From: Martyn White <Martyn.White@arun.gov.uk>
Sent: 28 September 2020 16:35
To: Amy Myer <Amy.Myer@arun.gov.uk>
Subject: LU/218/20/PL & LU/219/20/L

LU/218/20/PL & LU/219/20/L

Flintstone Centre East Street Littlehampton BN17 6AW

Erection of new fencing & gates to the rear & sides of building & removal of wire mesh fencing & gate between the playground & building. This application affects the character & appearance of the East Street Conservation

Drawing No:
001

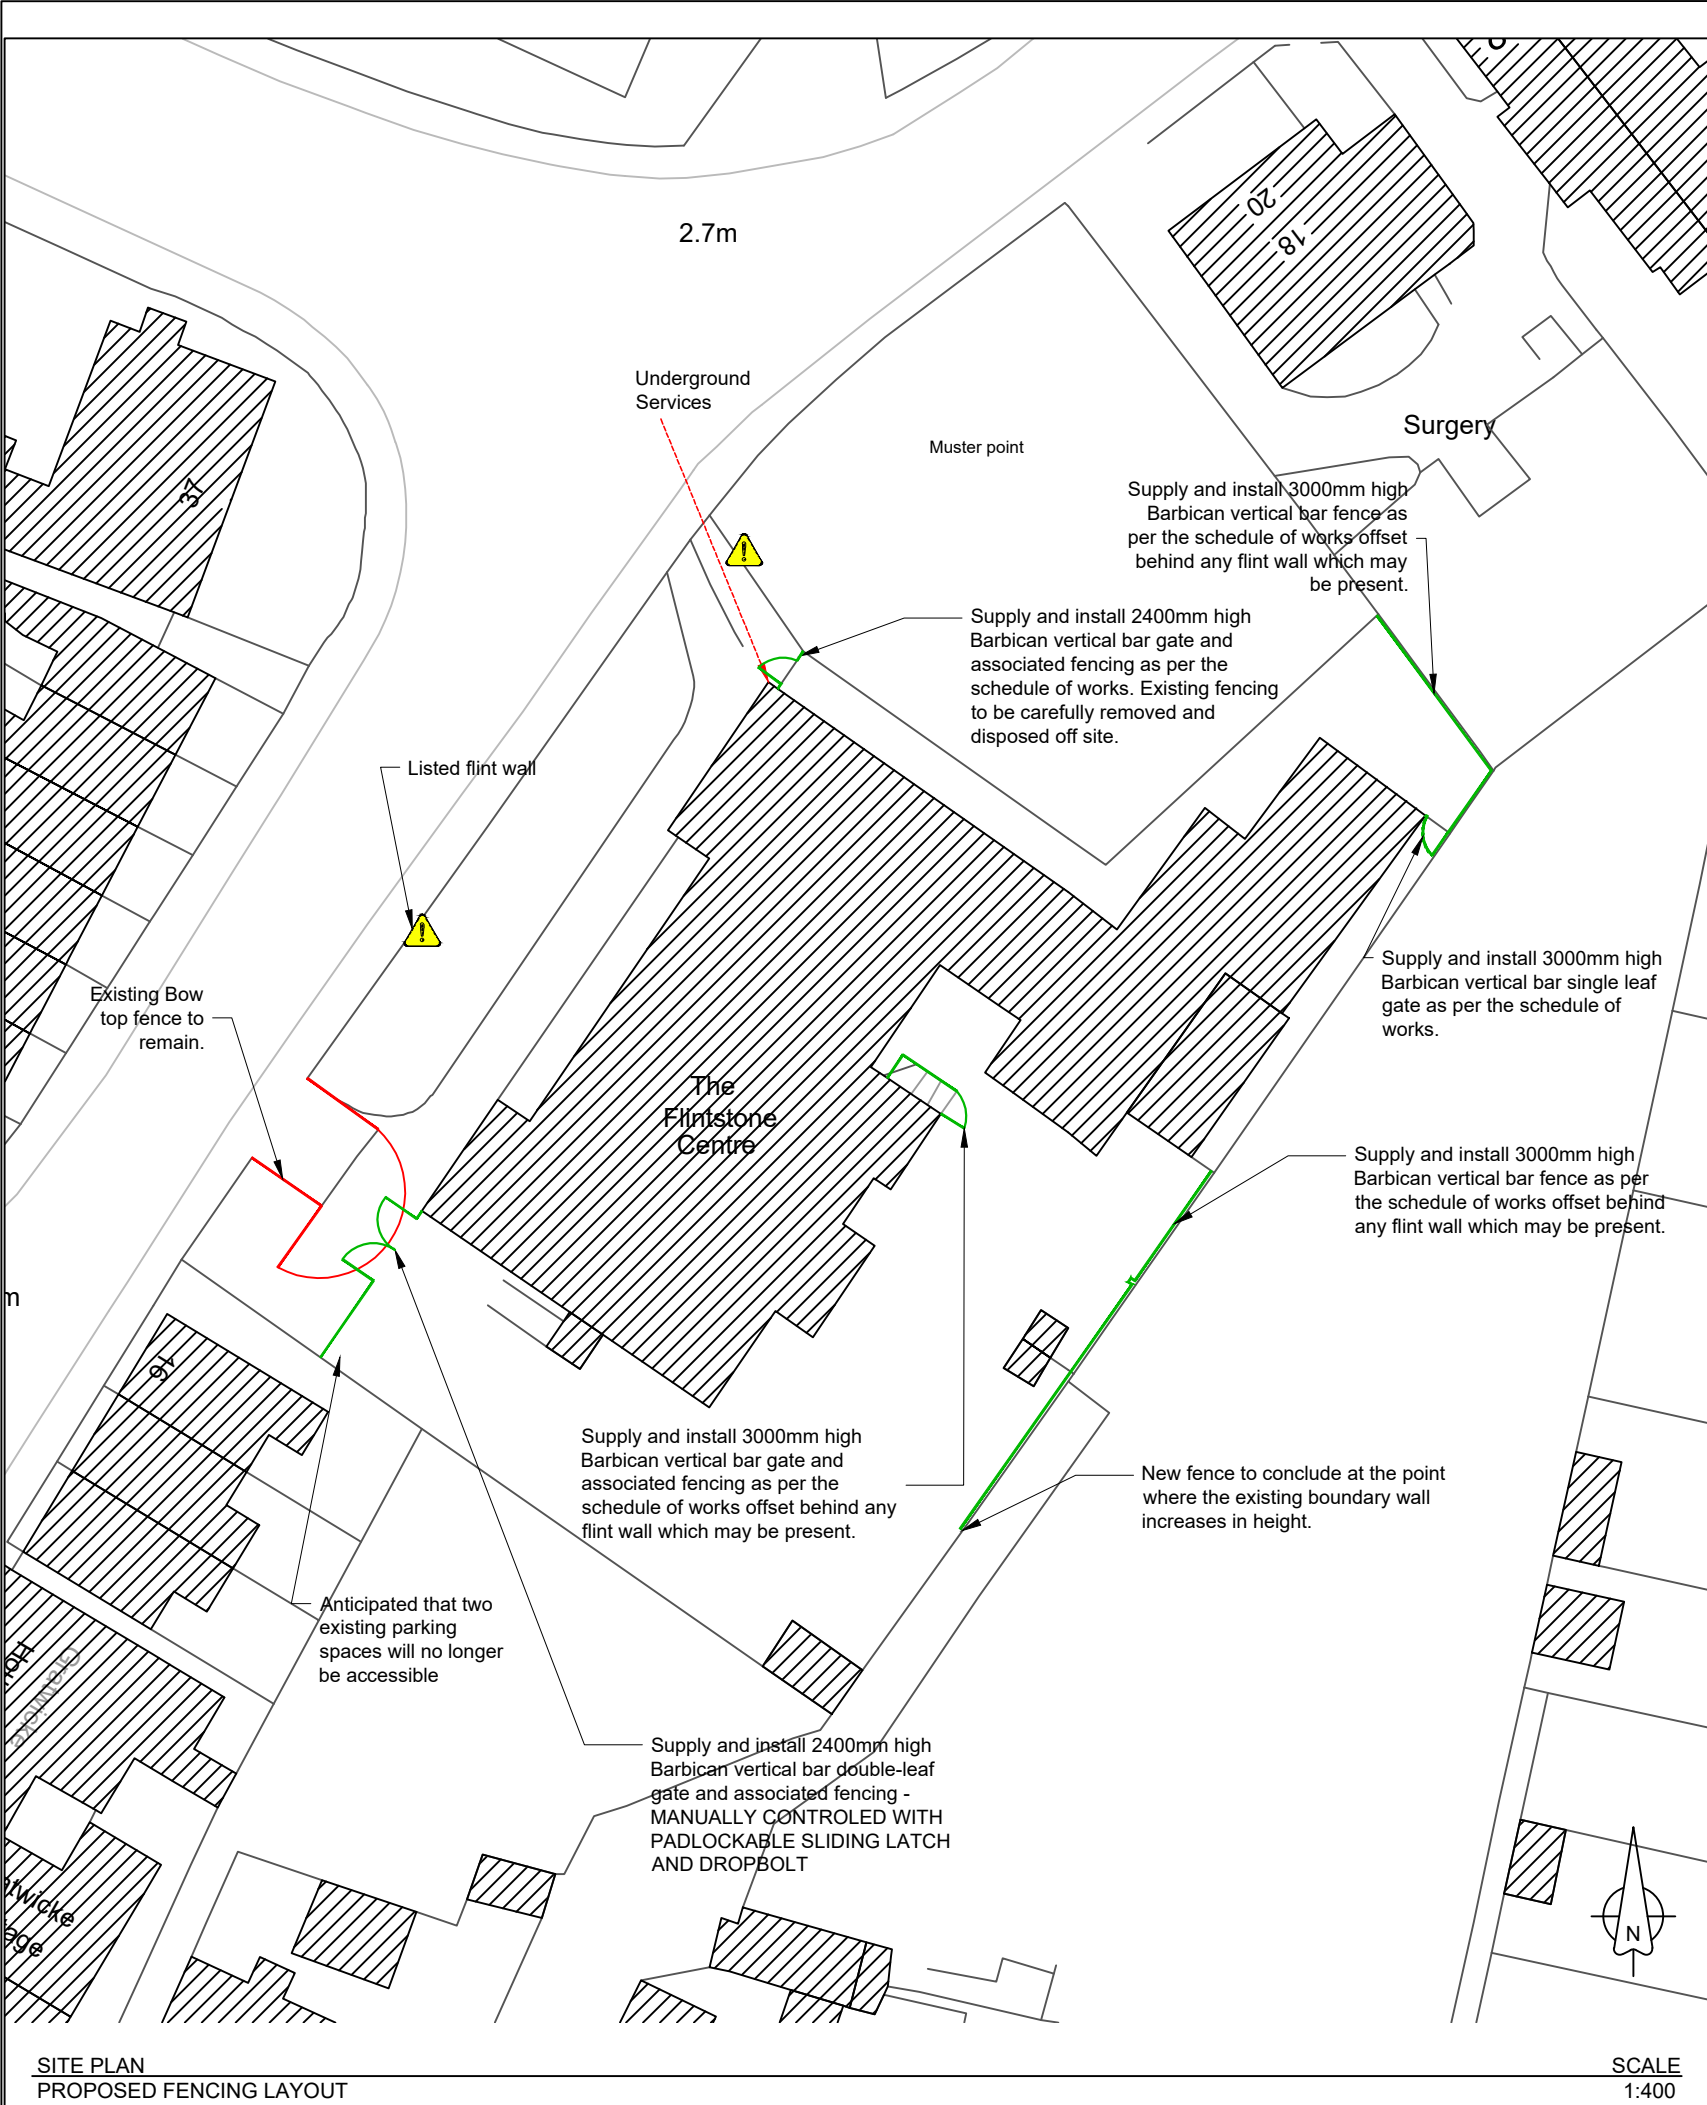
Erection of new fencing & gates to the rear & sides of building & removal of wire mesh fencing & gate between the playground & building. It is assumed that the existing mesh fencing which encompasses the playground will remain. Is this correct?

Of particular note is the element of the fencing which is located in the southern part of the site, and both clearly visible from the street and in the context of the listed building. Its height and appearance are not considered to be appropriate for the heritage asset or local area. It is therefore problematic. Further, it is not clear if any alternate, and more appropriate fencing has been identified or not.

It is noted from the case officer that a neighbour has requested that the fencing is altered so that it also protects her property. This would appear to be located to the rear of the listed building and form an extension to one of the new areas of fencing. This proposal would not result in any further harm, and in fact would be screened from the conservation area, and adjoin some modern development.
